AUGUST 24, 2012

RE: Review Comments for Single Family Site Plan

Project Name: White Single Family
Project ID: 2012-08-4687-SF
Project Address: 66 Shore Road, Cushing Island **CBL:** 106A-C-013001

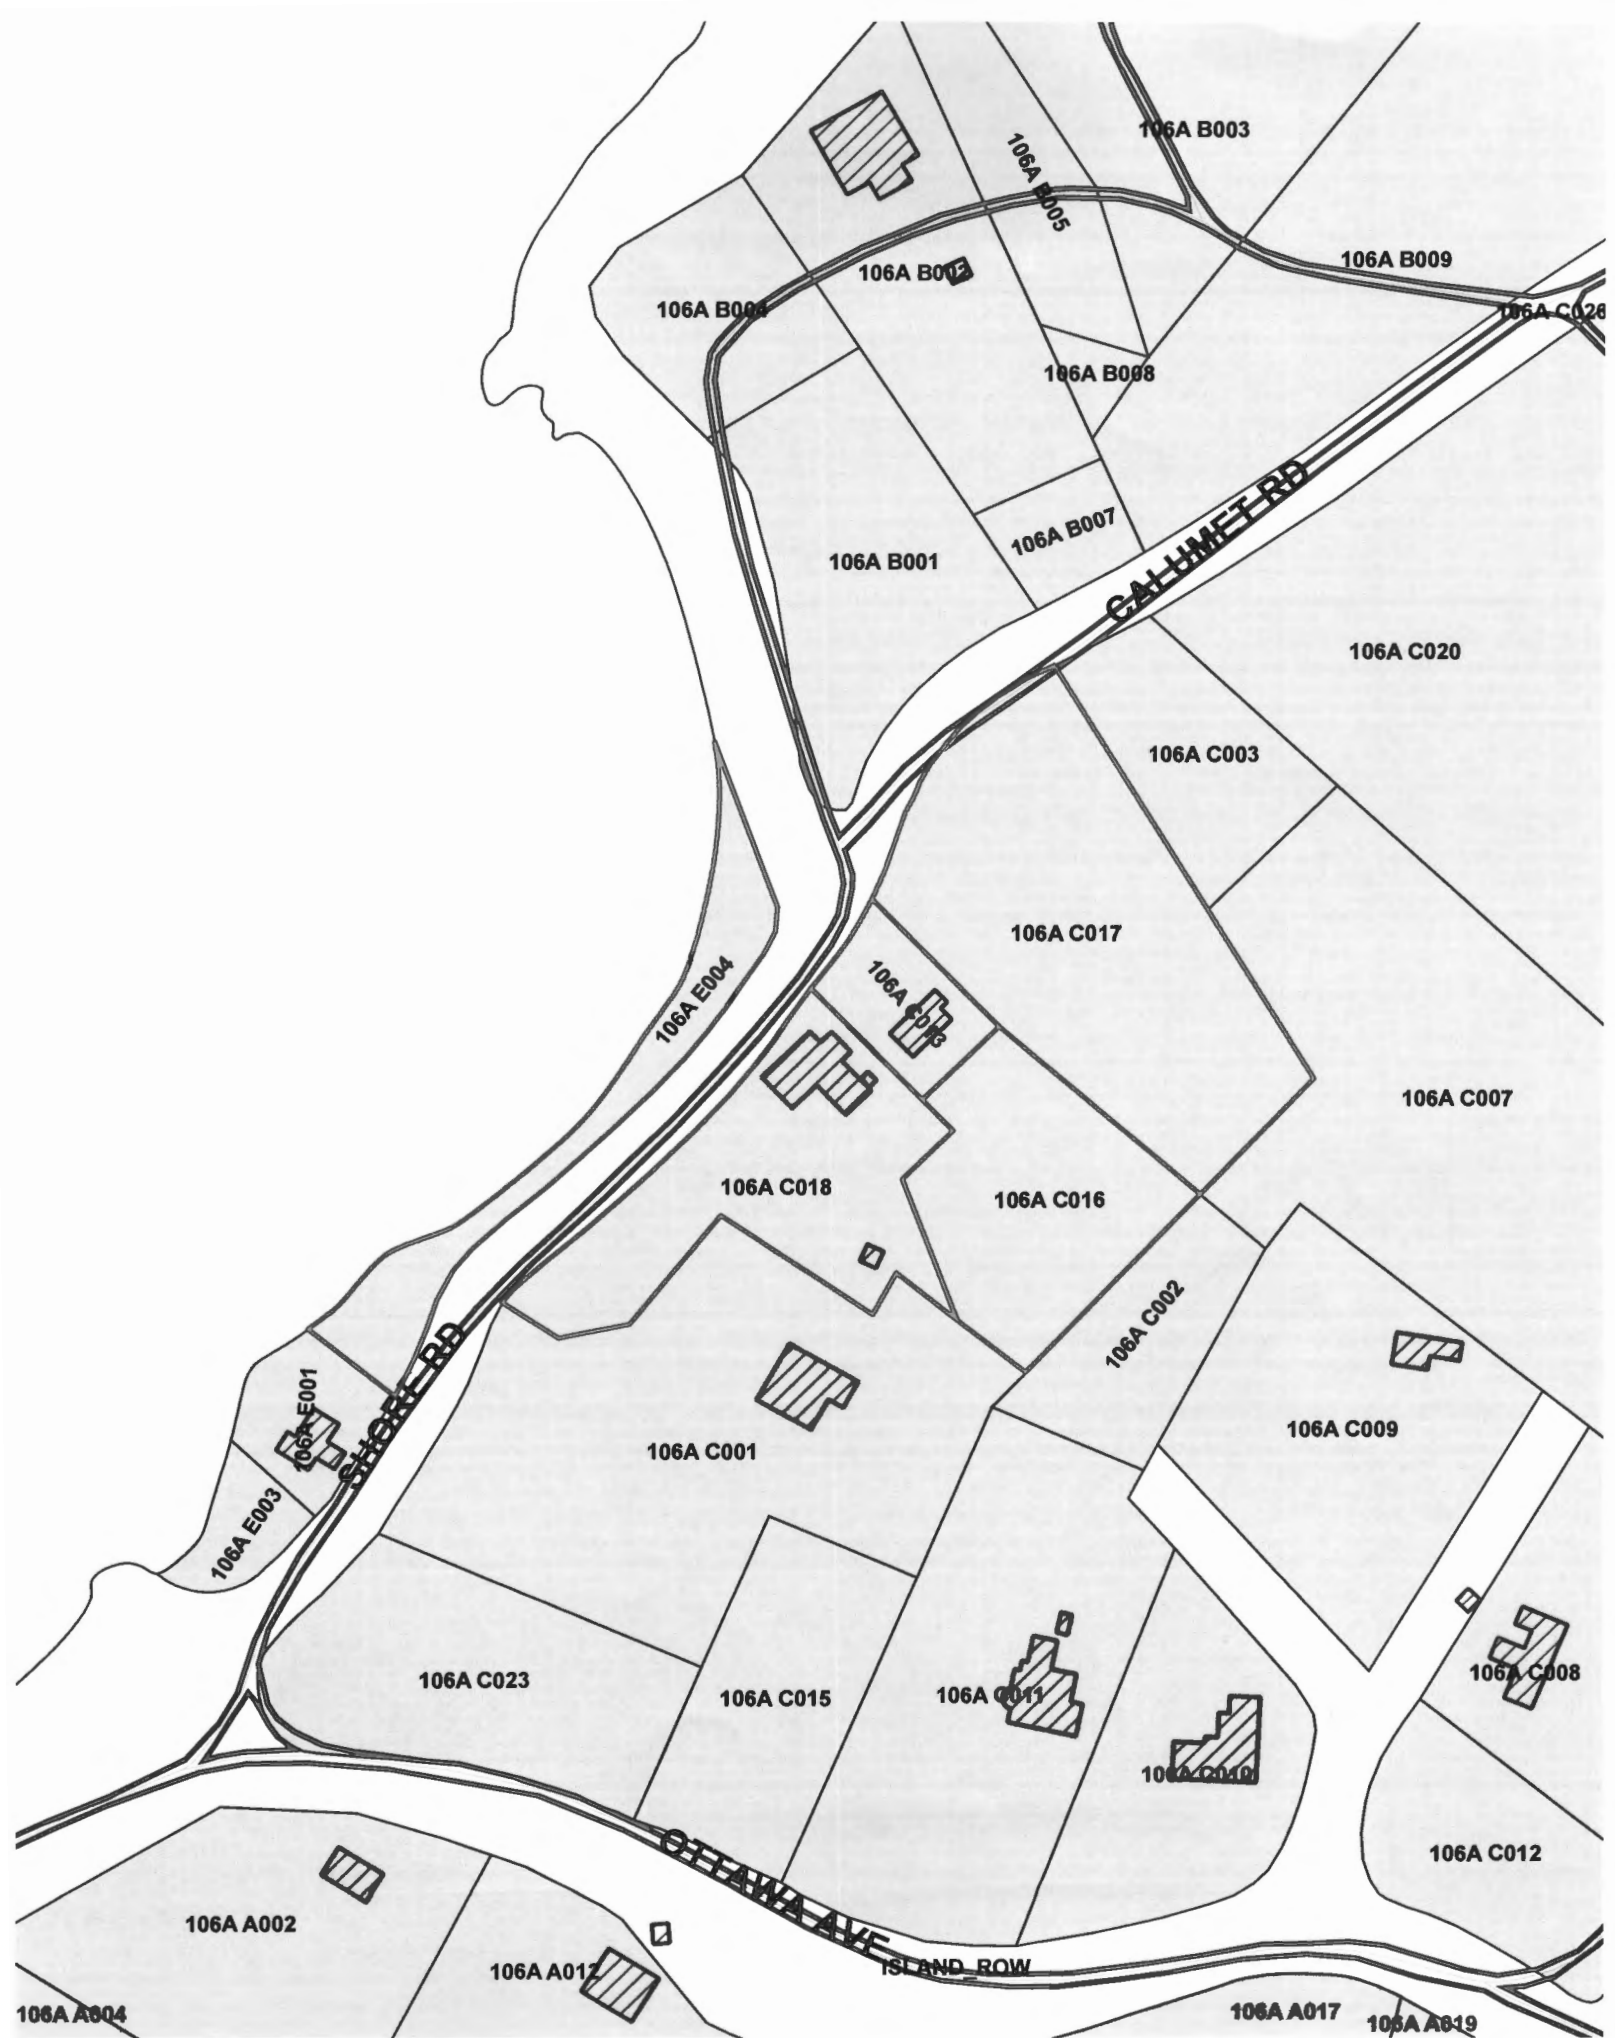
1. Please submit a revised site plan that includes the following information:
 - The site plan needs to show the 75' setback and the 250' setback from the high tide for the Shoreland Zone.
 - The existing cottage does not meet the 20' setback on the right side of the property. There is no evidence that the existing footprint is legal. If the owner can't show that the footprint was permitted, the new structure must be relocated to meet the 20' side setback.

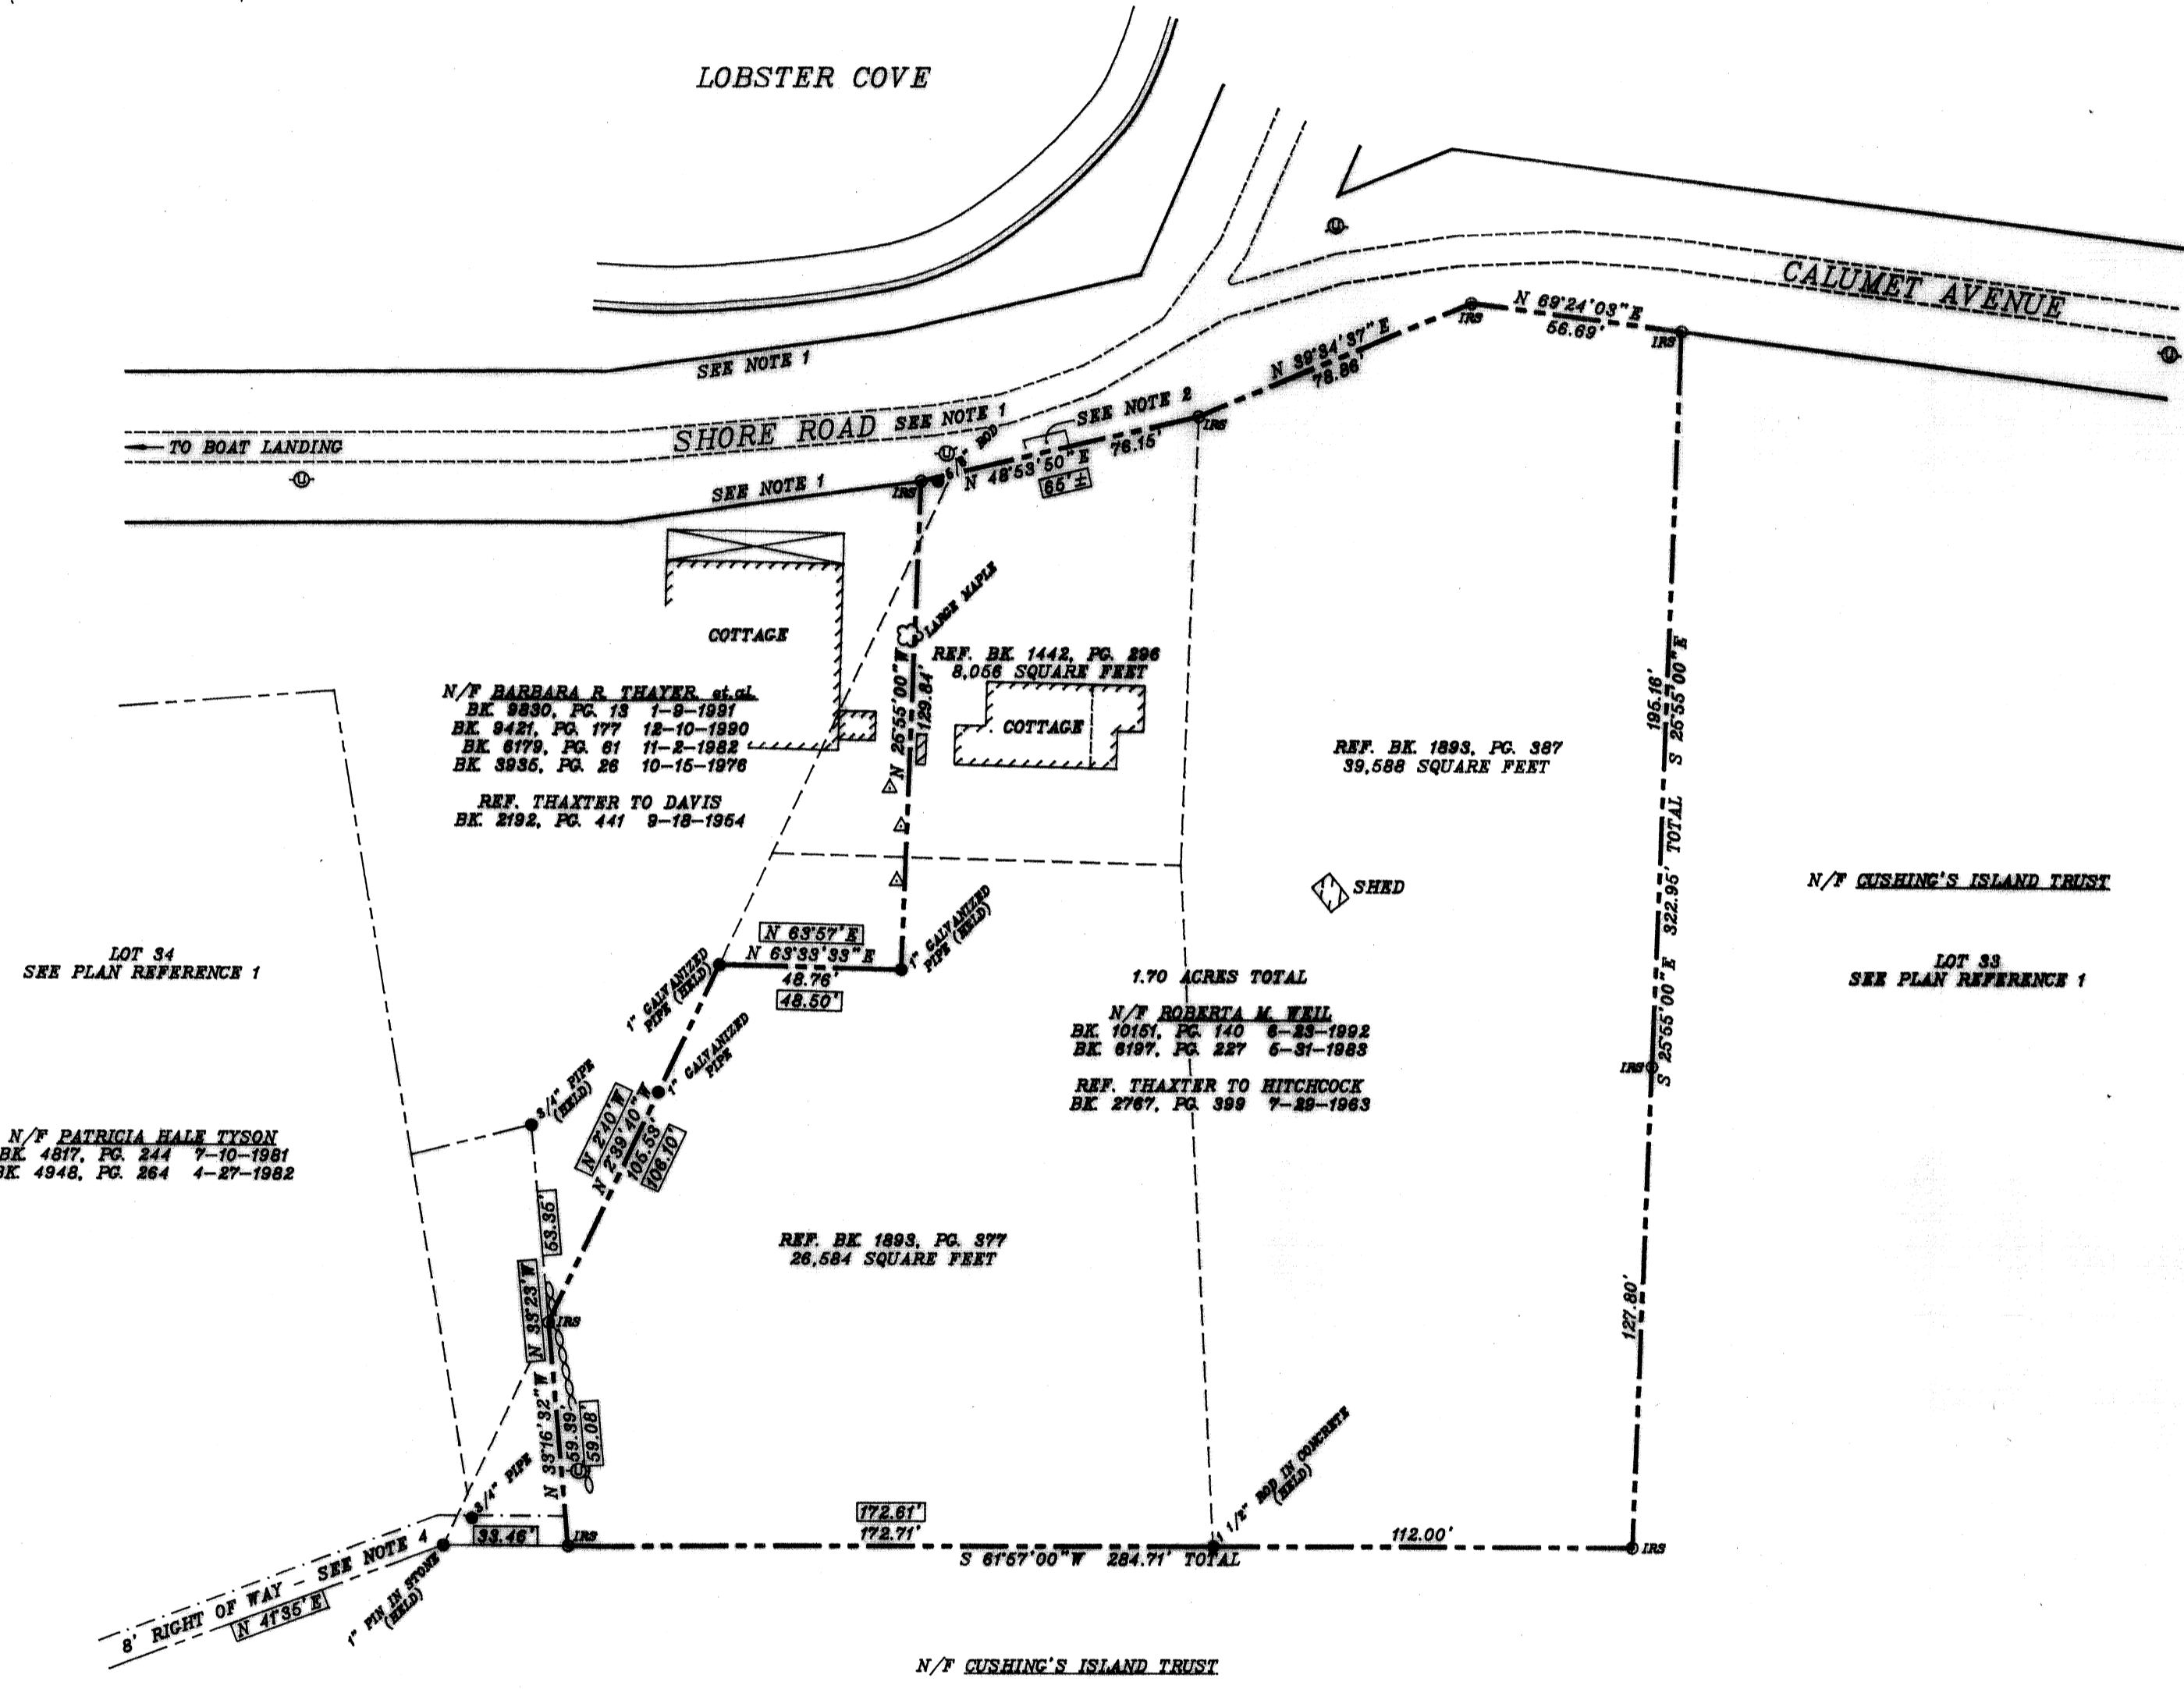
1. Please submit a revised survey to include the following information:
 - Please add the name and address, and the deed book and page numbers of the current property owner to the survey,
 - ✓ • Please add the flood zone information to the survey, ie. what zone the property is in based on the FEMA Flood Insurance Rate Map, - shown on site plan
 - Please add a revision block to the survey,

- Please reduce the width of the driveway opening at the street line. The maximum allowable driveway width at the curb line is 24 feet per the City of Portland Technical Manual.
